Approved for access by the Solid Waste Department.

Reviewer: Herman Gabeagos

Date: 04-23-24

G & S MEATS FREEZER
SITE DETAILS
REFUSE/SOLID WASTE
1333 ASPEN AVE NW
ALBUQUERQUE, NM 87104
PROJECT #2345

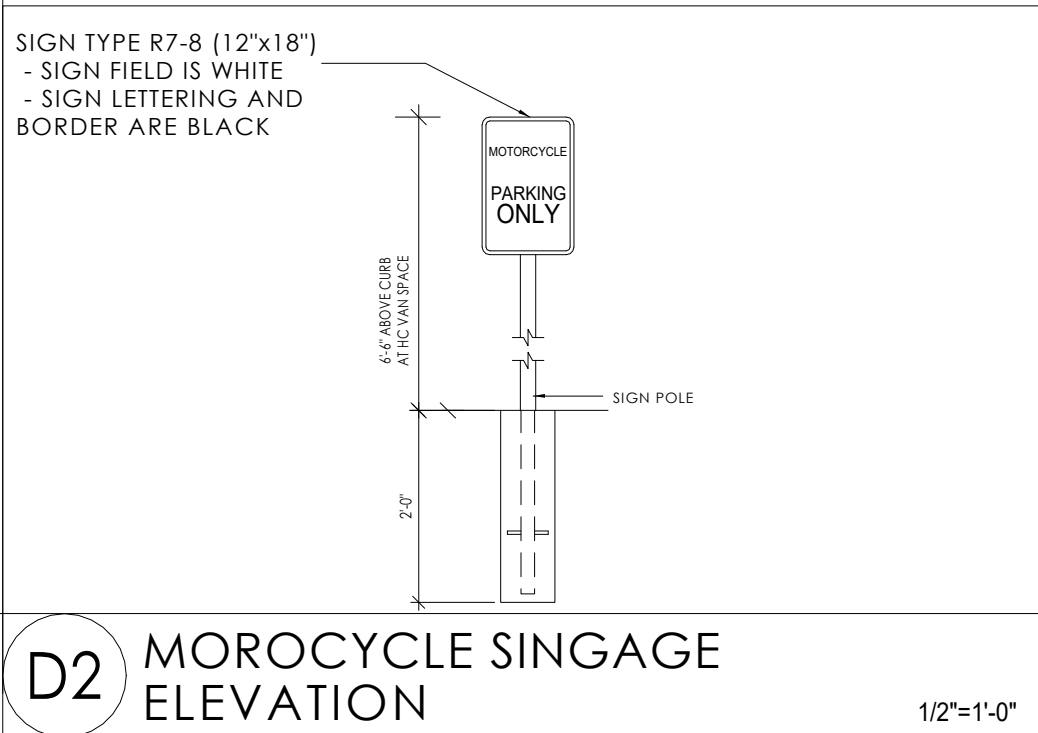
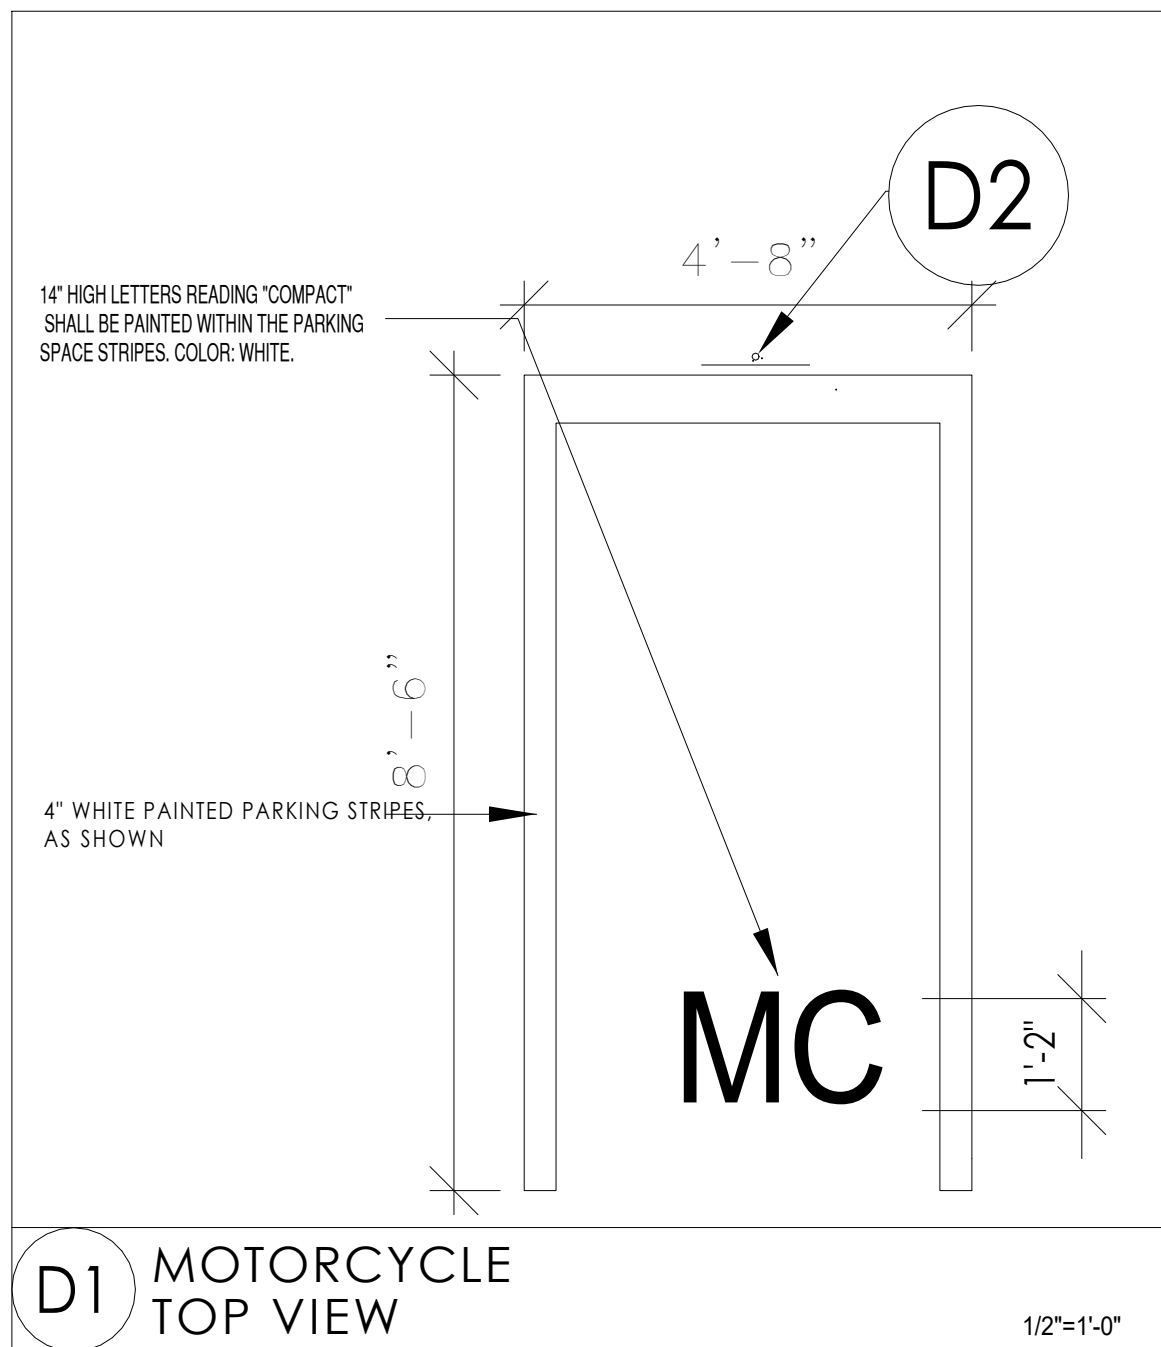
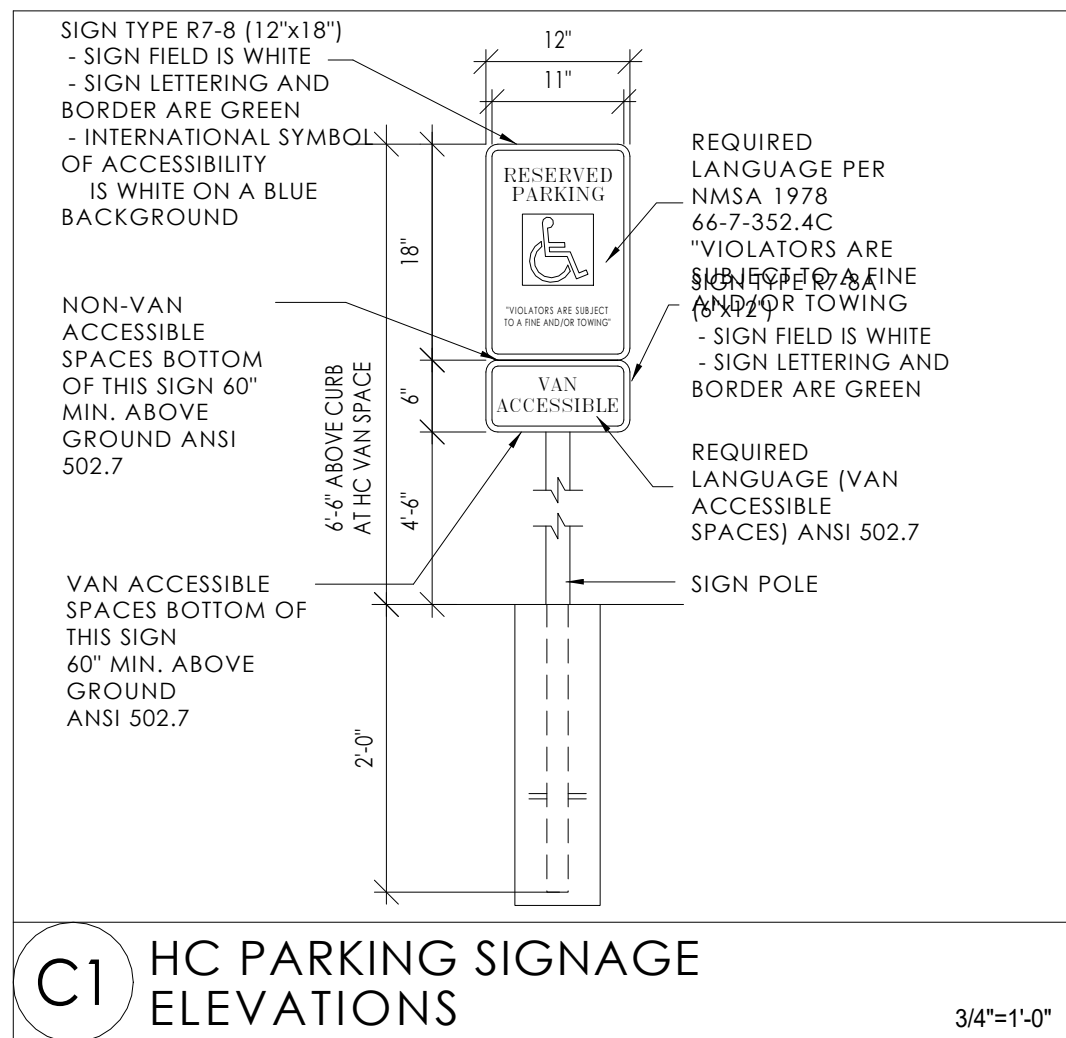
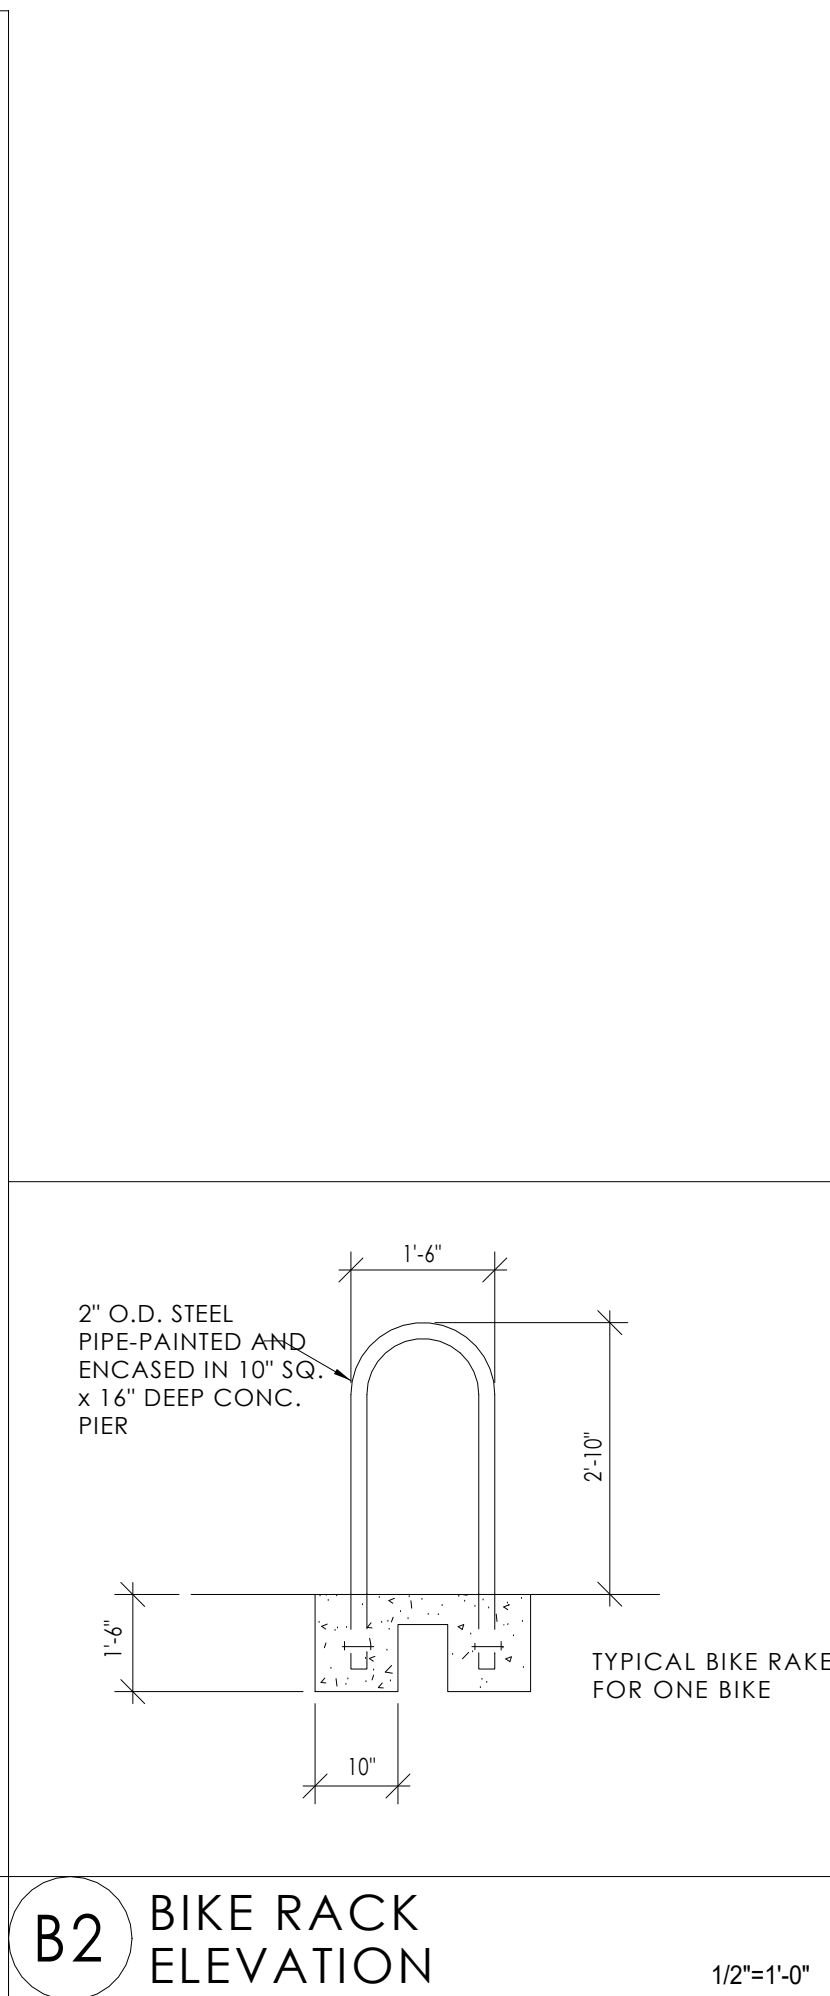
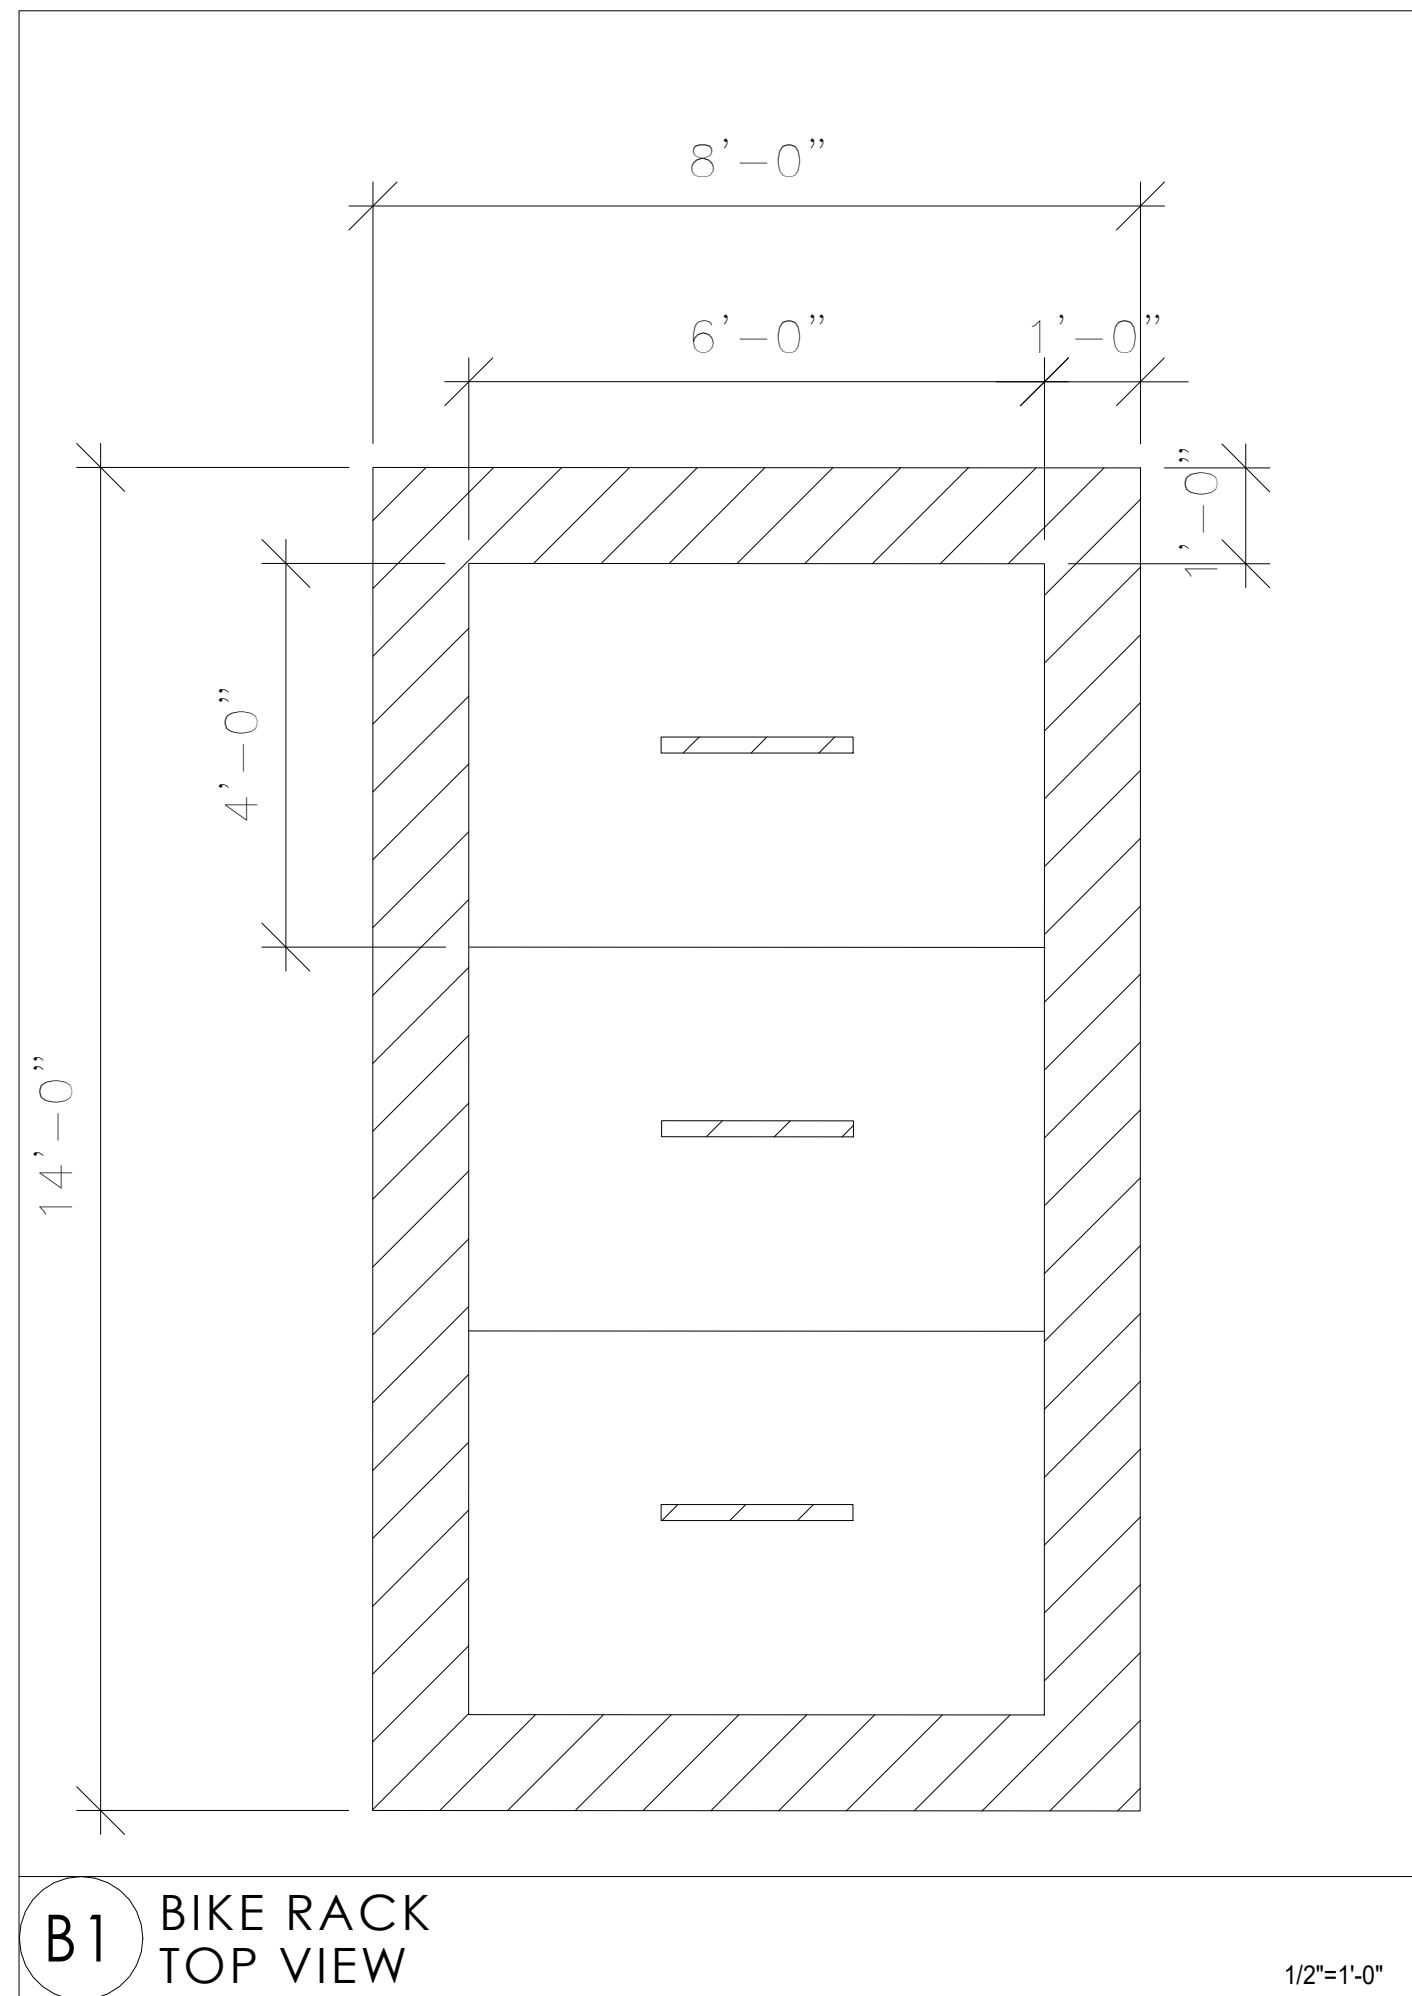
Recycling declined
See manhole note
